**KIRKLEES METROPOLITAN COUNCIL
INVESTMENT & REGENERATION SERVICE**

**DELEGATED DECISION FOR APPLICATION FOR CERTIFICATE OF
LAWFUL DEVELOPMENT**

Reference no.: 2026/CL/91470/E

Site: 14, Southfield Court, Highburton, Huddersfield,
HD8 0RG

client	JUSTIN HARGRAVE		
project	14 SOUTHFIELD COURT KIRKBURTON HUDDERSFIELD HD8 0RG		
drawing	PROPOSED PLANS AND ELEVATIONS		
revision	notes	date	drawn
scale :	1:50 AT A1	05.26	MG
project no.	2497	drawing no.	02
		revision

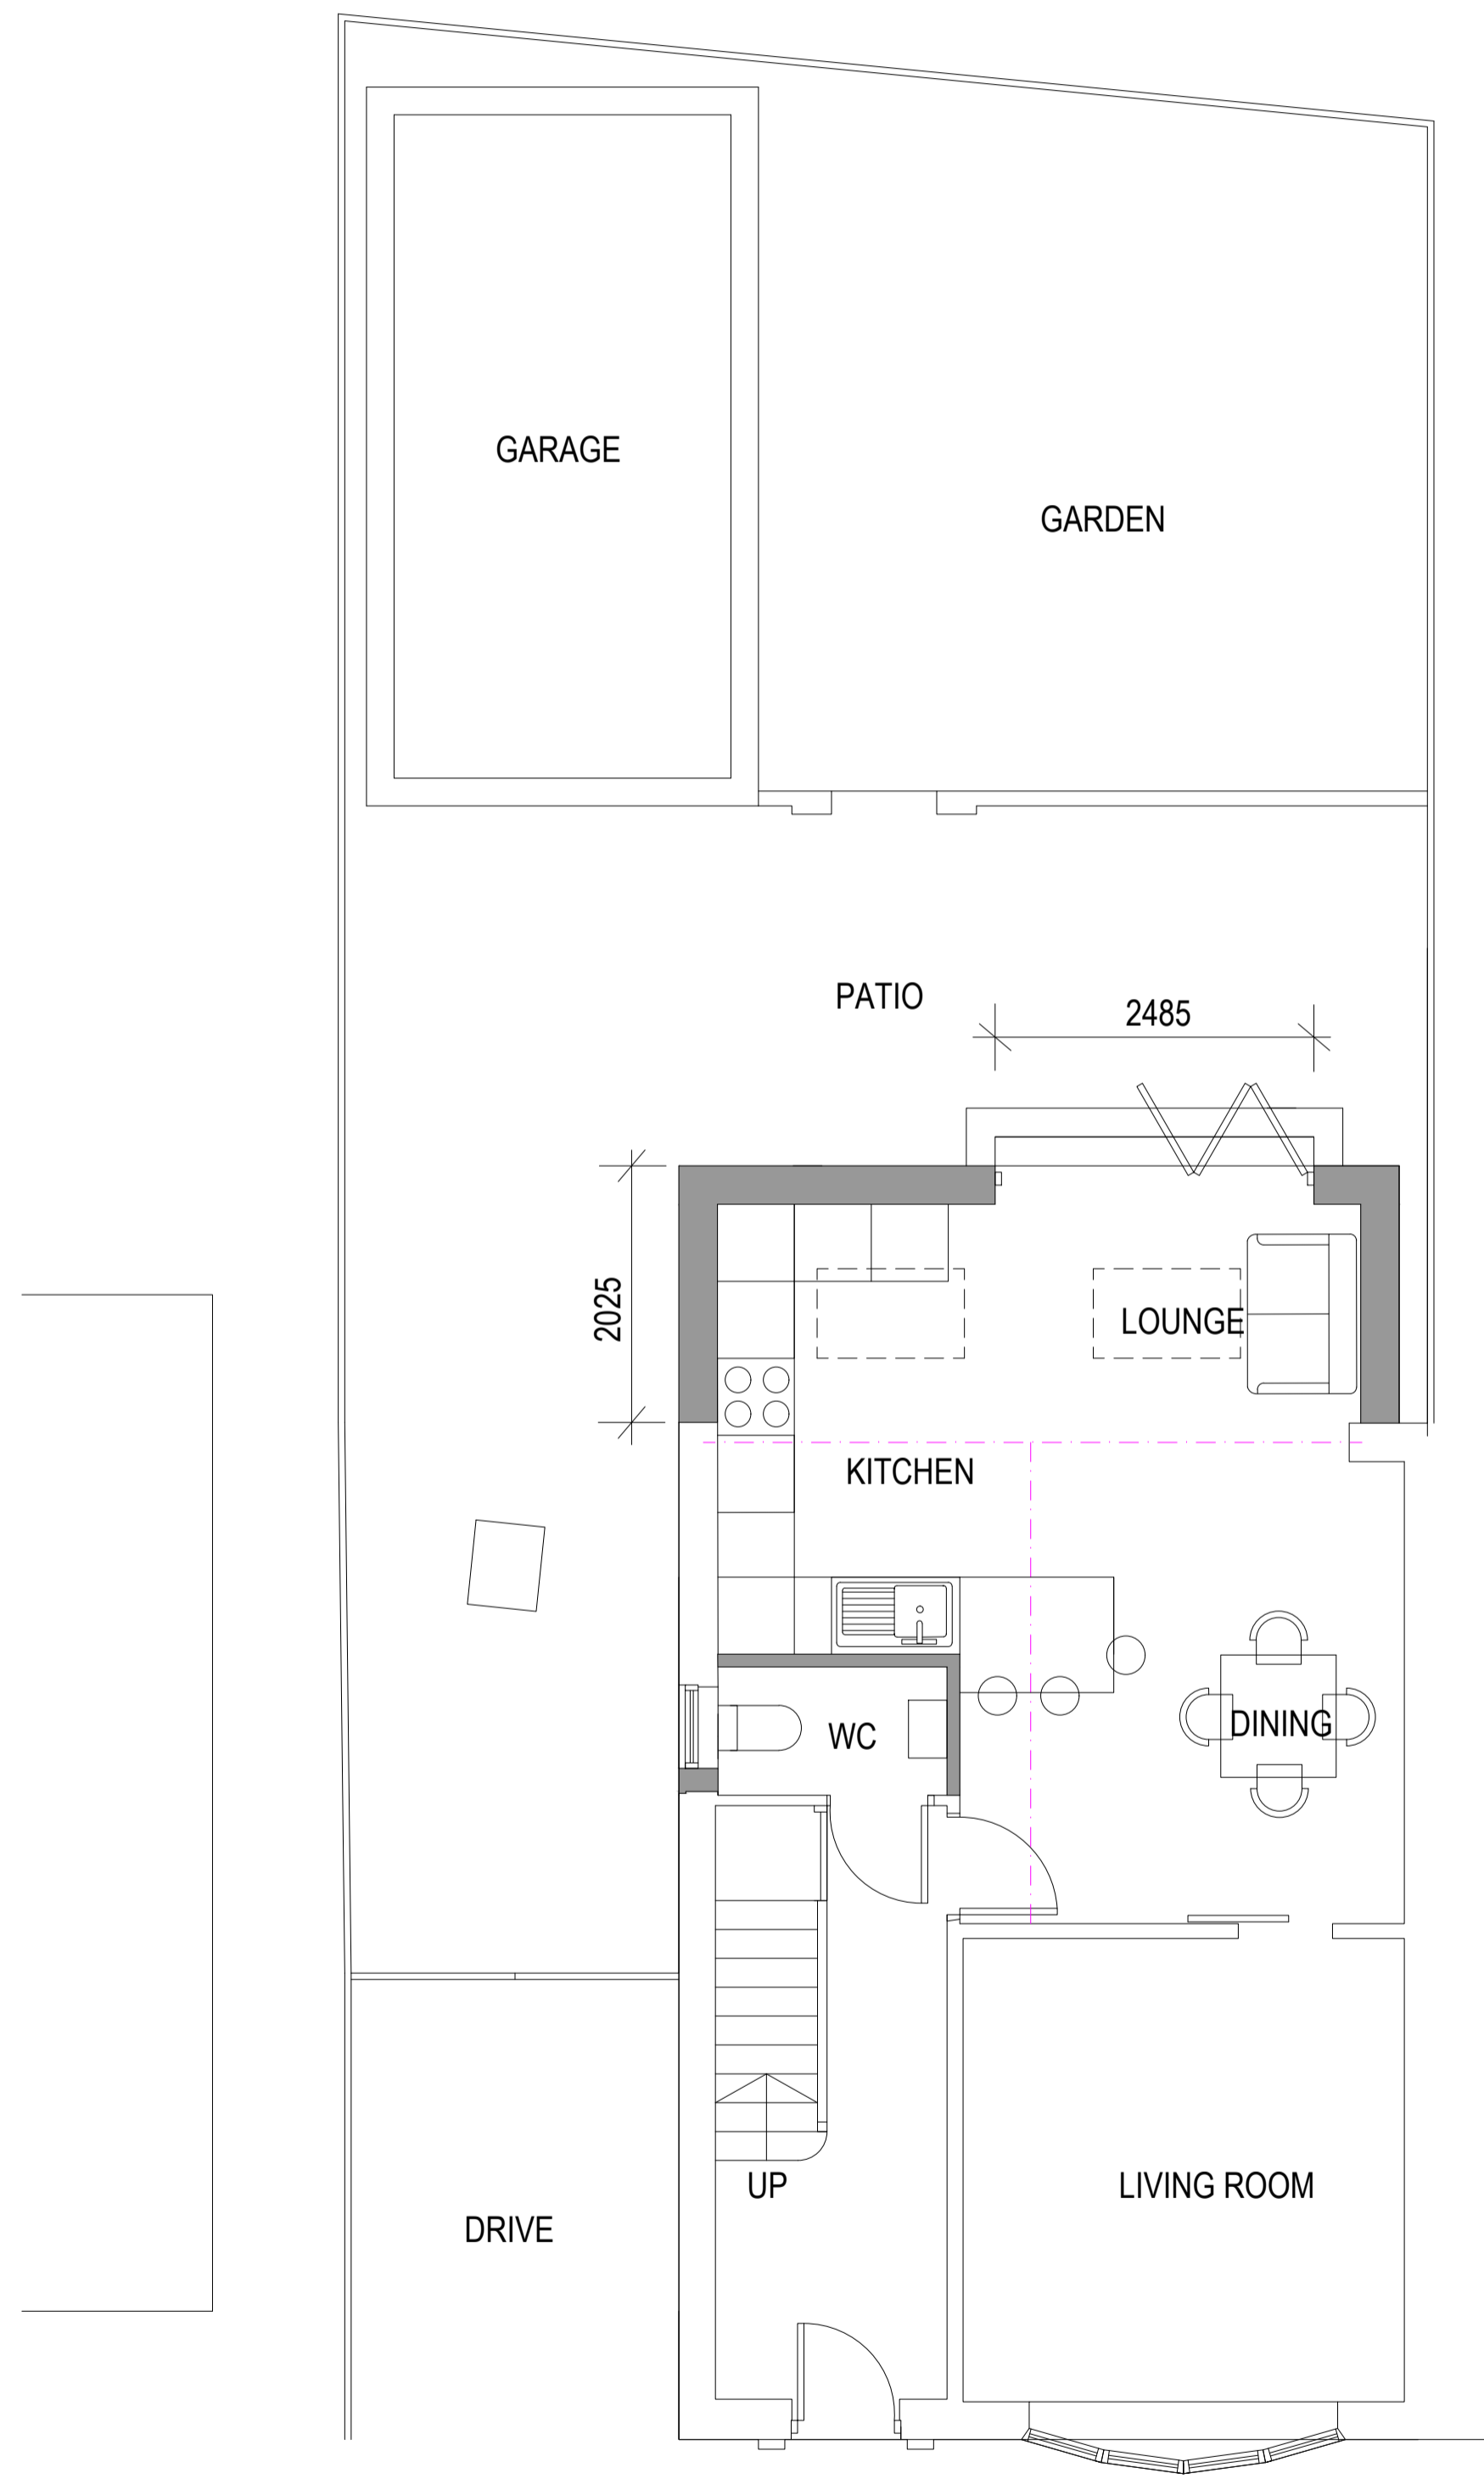
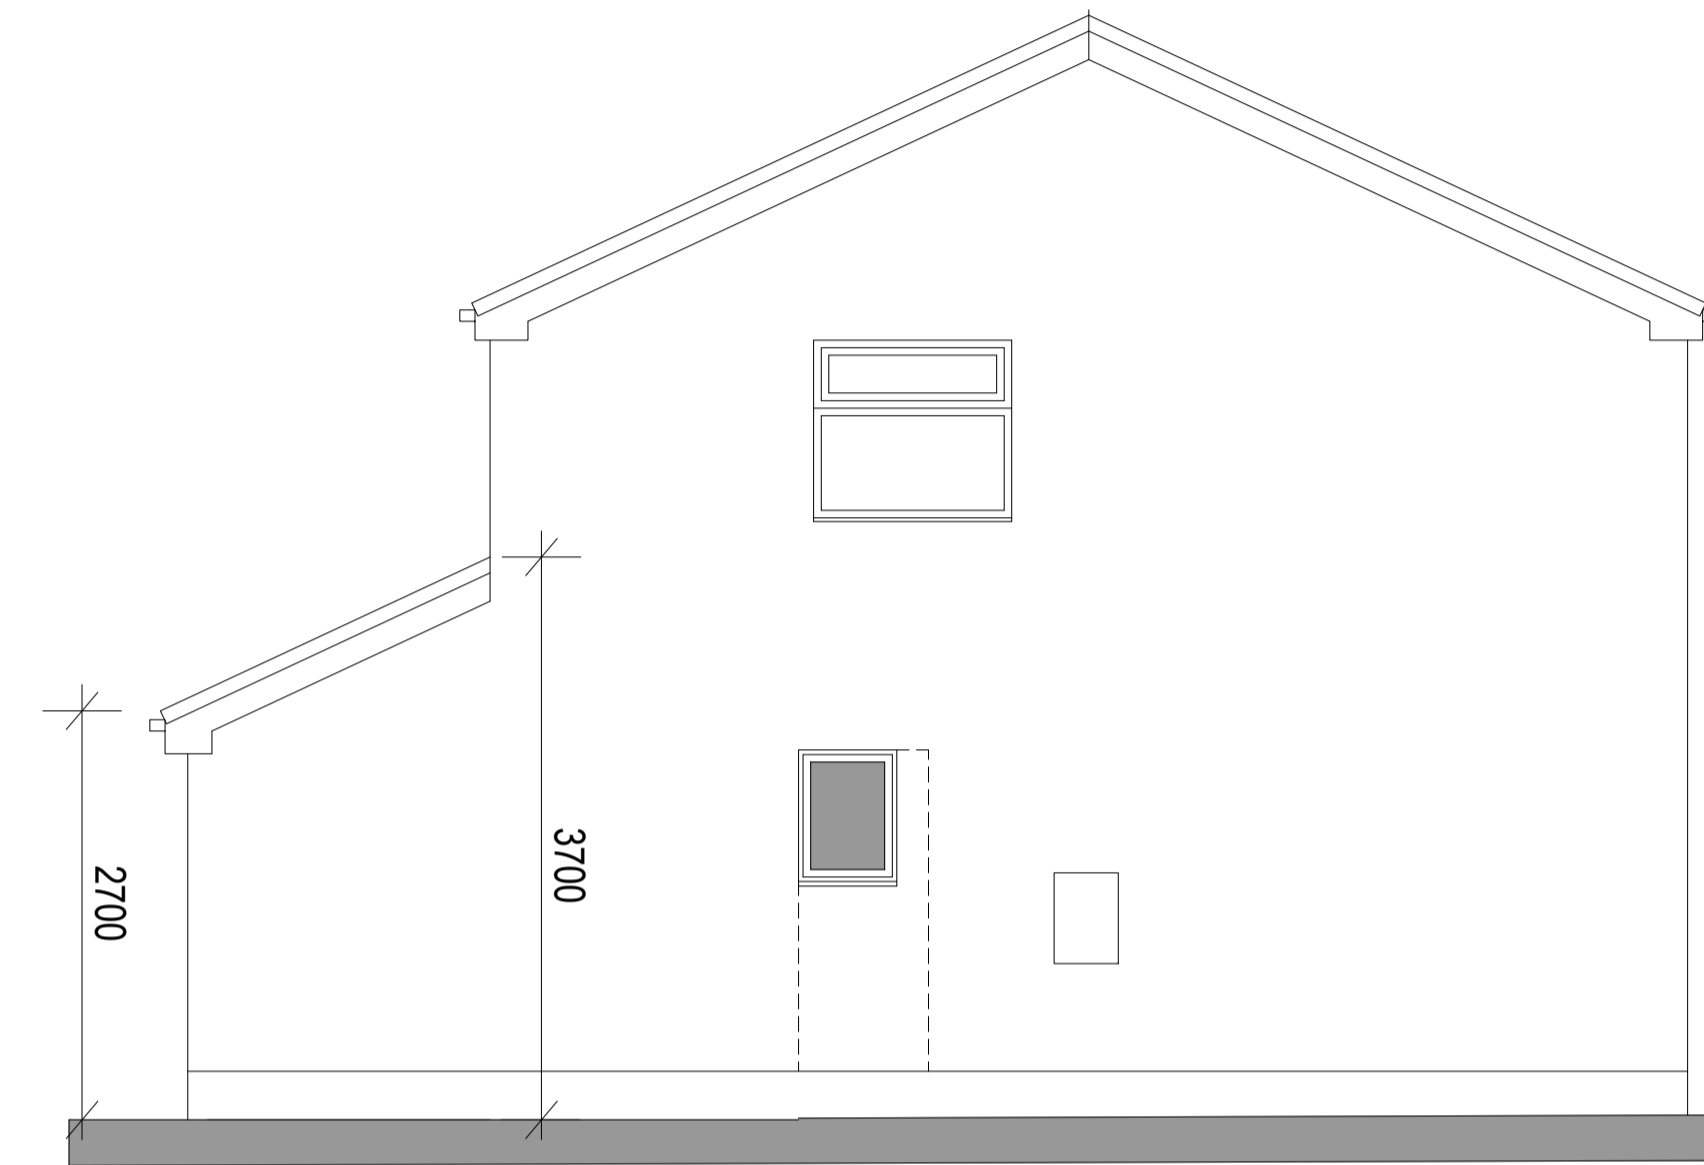
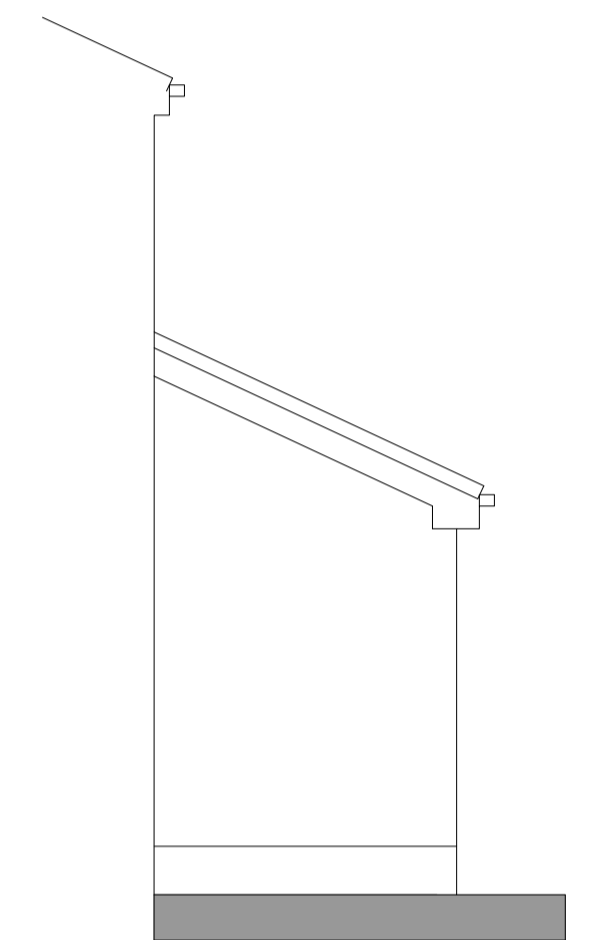
The proposed extension would be 2 metres in projection and would span the full width of the rear elevation. The eaves height would be 2.7 metres with the overall height of the lean-to roof being 3.7 metres.

Comment: *The enlarged part of the dwellinghouse would be within 2 metres of the boundary of the curtilage of the dwellinghouse however the eaves height of the eaves would not exceed 3 metres.*

Comment: *The proposed extension would project both to the side and to the rear of the existing outrigger. Because it extends beyond the outrigger's side wall, it is considered to be located on the side of the original house. It also extends further back than the outrigger itself, creating a combined side-and-rear enlargement. When assessed as a wrap-around extension, the overall width of the enlarged part would exceed half the width of the original dwelling and therefore fails to meet this part of the criteria.*

The single storey rear extension does not benefit from a general planning permission under Article 3(1) and Schedule 2, Part 1, Class A of the Town and Country Planning (General Permitted Development) (England) Order 2015 (as amended) as the proposed enlargement would extend beyond a wall forming the side elevation of the original dwellinghouse and would have a width more than half the width of the original dwellinghouse contrary to sub-paragraph A.1 (j) (iii) of Class A.
